Our Ref: BN/126/21/DOC

Approval of details reserved by condition imposed under ref W/4001228 (BN/24/20/PL) relating to Condition Nos 3 - materials and finishes, 5 - noise, 6 - dustbin enclosure, 7 - renewable energy, 10 - covered & secure cycle parking, 11 - electric vehicle charging, 12 - surface water drainage and 13 - foul drainage.

Tile Barn Farm 32 Hill Lane Barnham PO22 0BL

External Materials – Photo Sheet

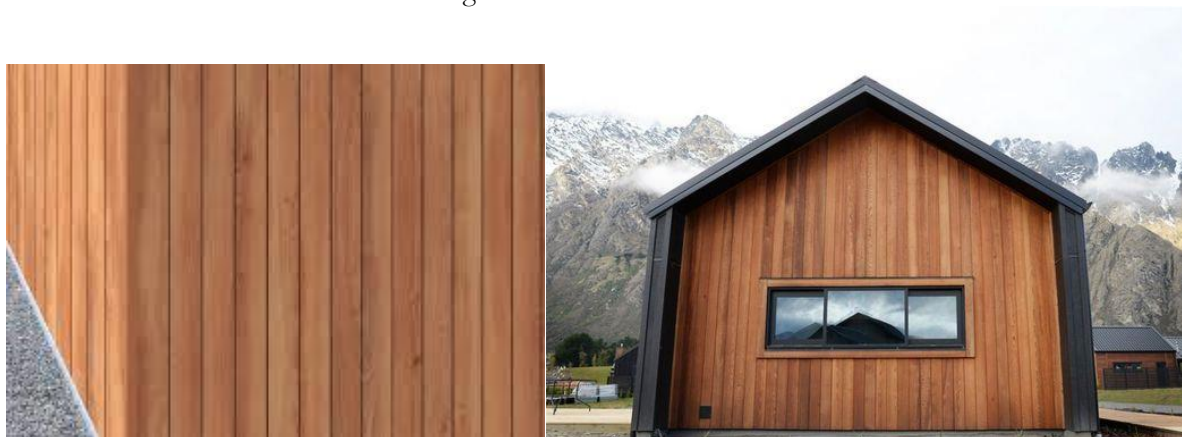
Officer comment: It is noted that there are some discrepancies between the approved drawings under BN/24/20/PL and the submitted photo sheet for BN/126/21/DOC i.e. side walls shown in approved drawings as slate tiles but in photo sheet reference made to timber side walls, and the gable fascia is shown in approved drawings as steel but in photo sheet reference is made to zinc. Notwithstanding that, the materials proposed in the photo sheet would be acceptable.
